Appendix A – Liverpool Hospital Multi Storey Car Park (SSD 10388) - Response to Agency and Public Submissions

Agency Submissions and Response

LHAP MSCP: Overland flows during construction
TTW 07/08/20

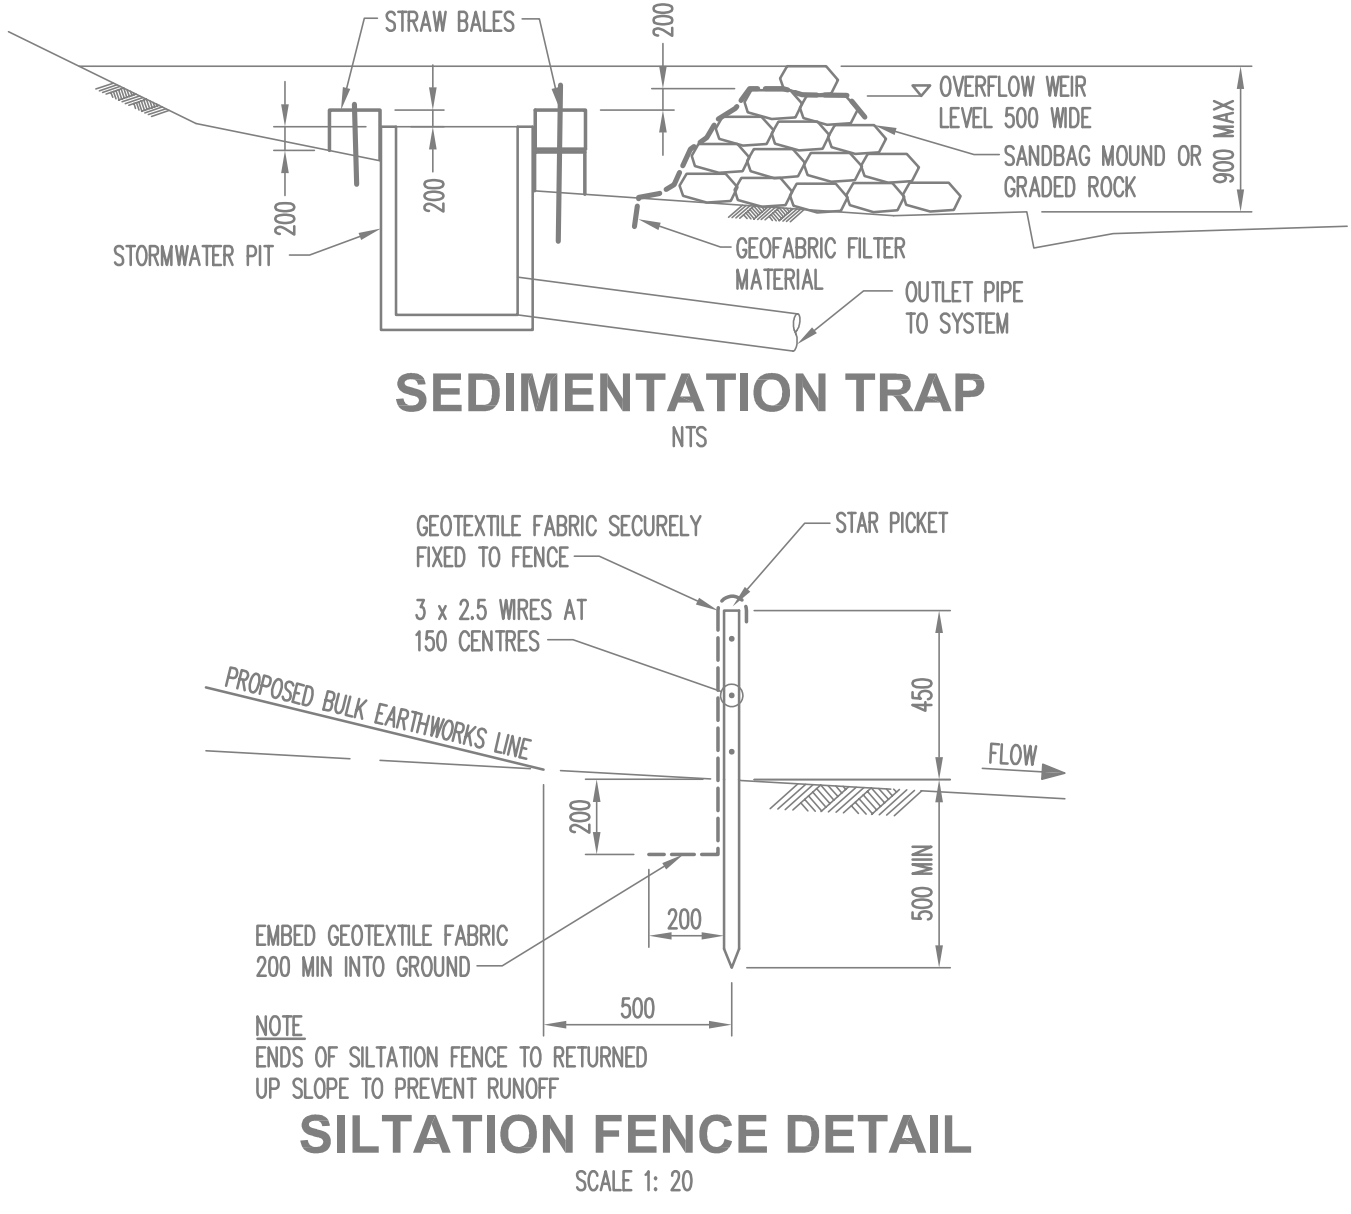
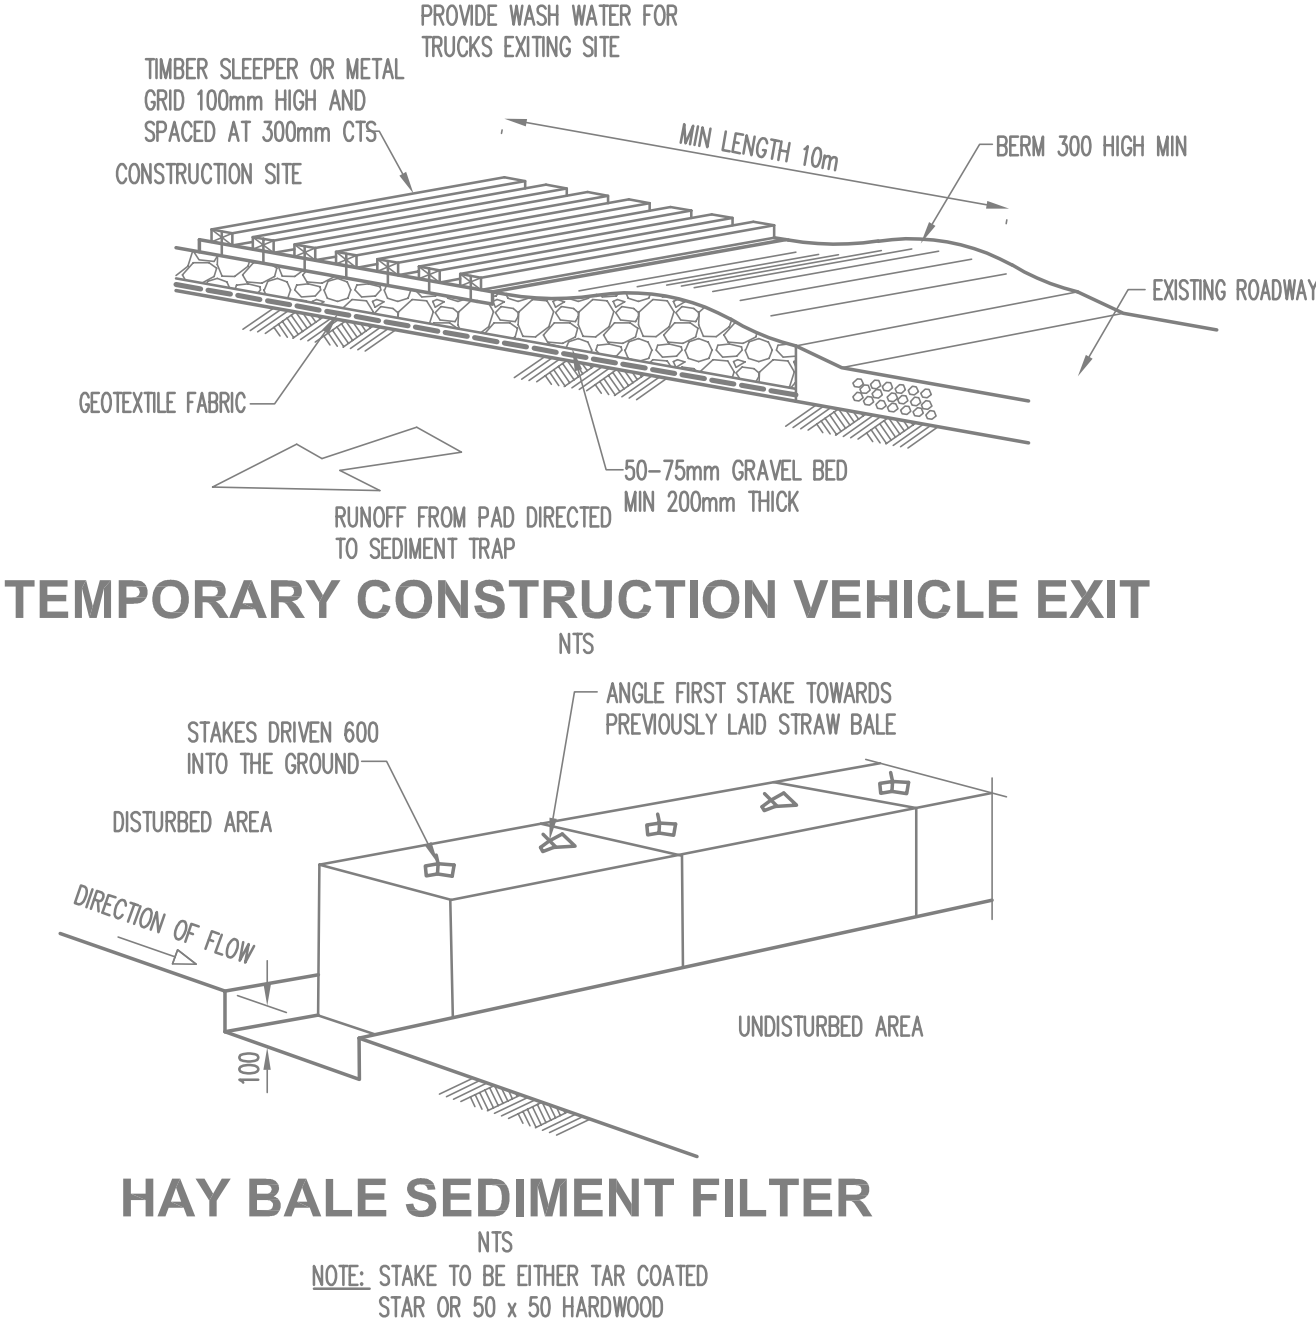
Noise Detailed justification must be provided for the significant works proposed outside of recommended construction hours, including justification for noisy works occurring on Sundays. If works outside of recommended construction hours are proposed, a works plan must be included to detail how often works would occur outside the recommended times and the period of time these works would continue.	The proposed scope of work to be undertaken outside the recommended standard hours has been assessed by Acoustic Logic and is included at Appendix F .
Flooding Noting the hospital campus is subject to mainstream flooding and overland flows, detail of modifications to flows that will occur both during construction and once the development is complete is to be provided. This must include detail of how flows will be managed during construction, particularly during the demolition and excavation phases of works, and include detail of where flood levels will increase in the surrounding area (including offsite) as a result of the alteration to flows through the hospital campus.	Plans illustrating the existing, during construction and post construction overland flow directions have been prepared by TTW and are included at Appendix L . The plans illustrate that all overland flow from the construction site will be managed through siltation fences, sediment traps or filter pits. The plans illustrate that the proposed construction works will not impact any external overland flow paths. Further, the post development overland flows are consistent with the pre-development overland flows.
